# **SCOPING OPINION:**

## **Temple Oaks Renewable Energy Park**

**Case Reference: EN010126**

**10 August 2022**

Plate 2 - Alternative Grid Connection Routes

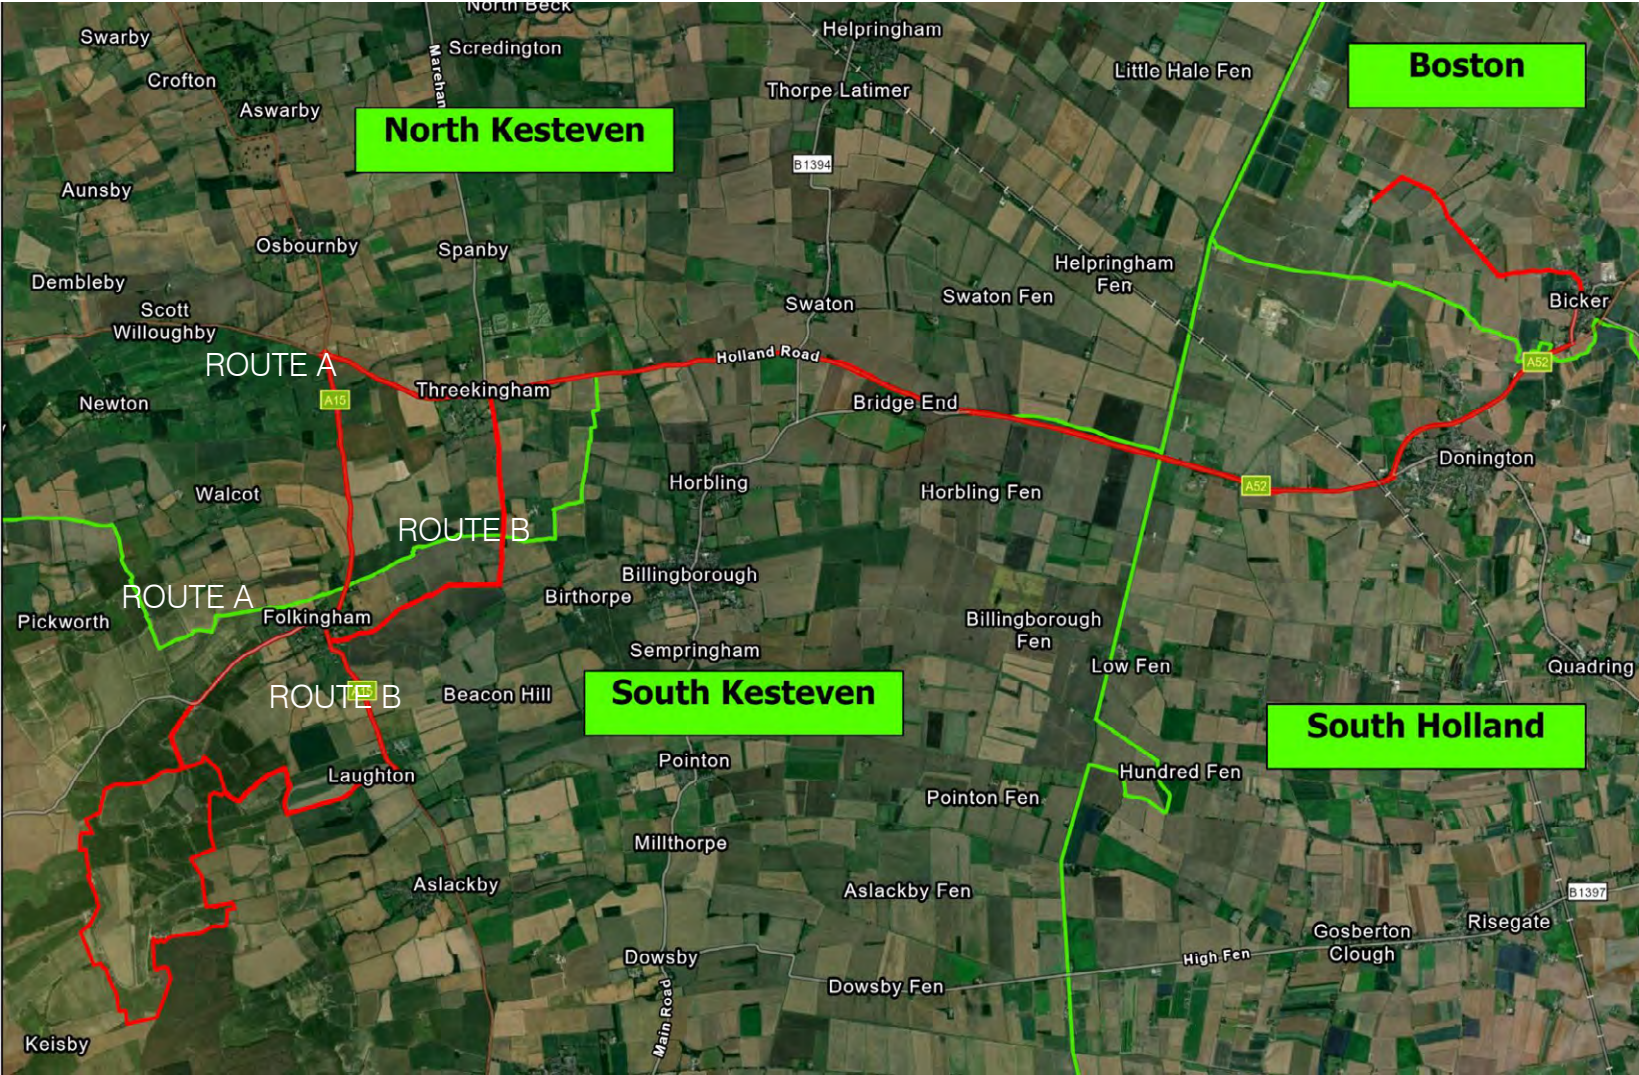
2.2.4	Plate 2 and paragraph 28	Grid connection route	<p>Plate 2 of the Scoping Report shows the two options for the grid connection route; Route A and Route B, but this is difficult to understand due to both routes being shown in the same colour and points where the lines cross over one another.</p> <p>It appears that a section of Route B exiting the site to the village of Laughton may use farm access tracks rather than roads, though this is not clear with the plan provided at Plate 2.</p> <p>The final route for the grid connection should be clearly described and shown in the ES. Any land additional to land in the highway which may be required for the construction or operation of the cable corridor should be identified. Any reinstatement works should also be described.</p>

Plate 2: ZTV and Suggested Viewpoint Locations

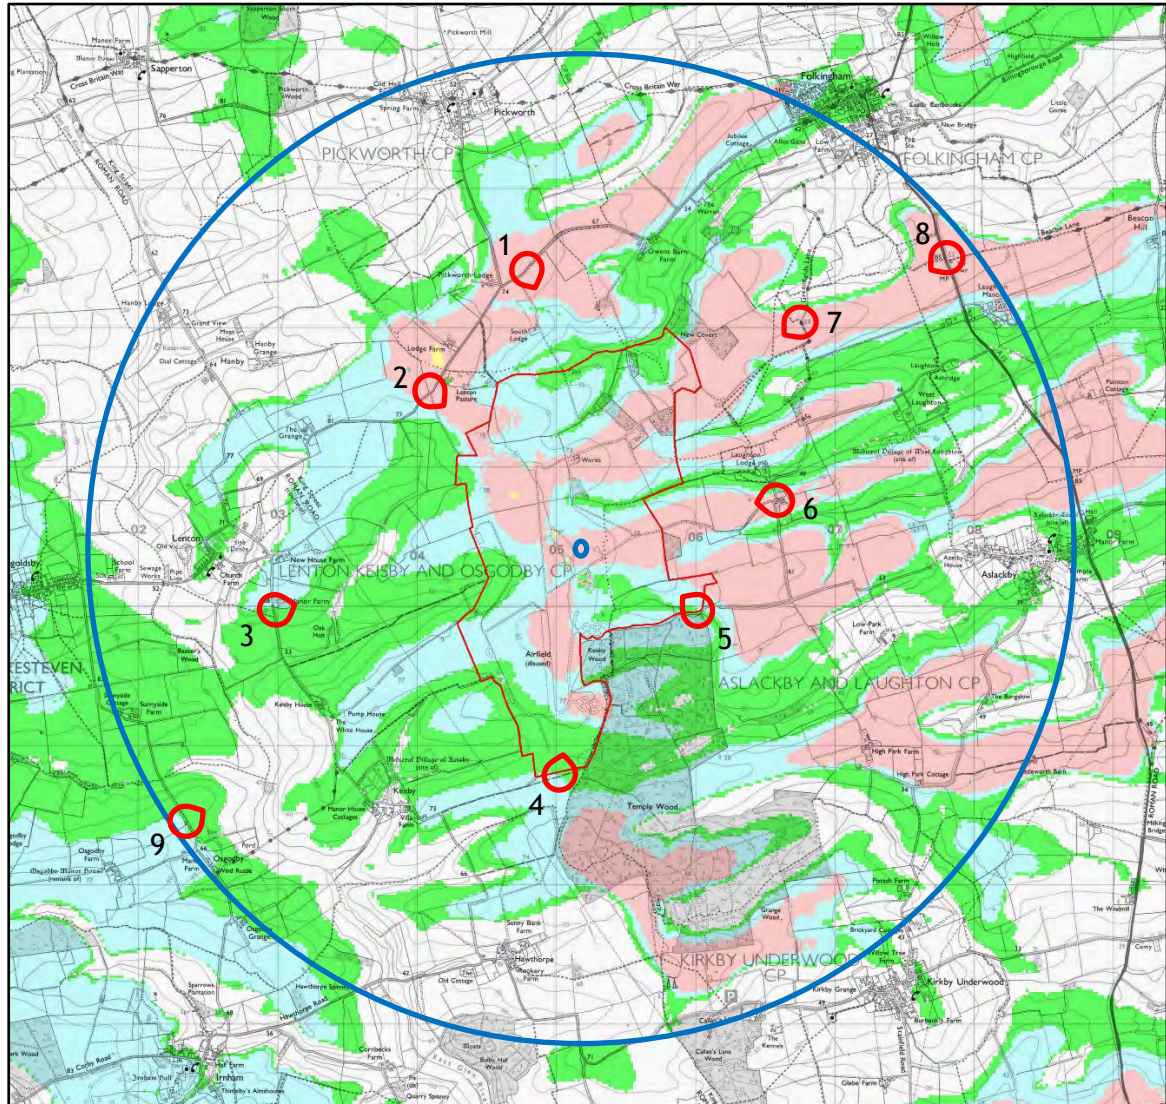
3.1.5	Appendix A paragraph 34	Zone of Theoretical Visibility	Paragraph 34 of the Scoping Report provides details regarding the ZTV. The Inspectorate considers that central inverters should be included within ZTV1 or ZTV2 to ensure maximum parameters are assessed.
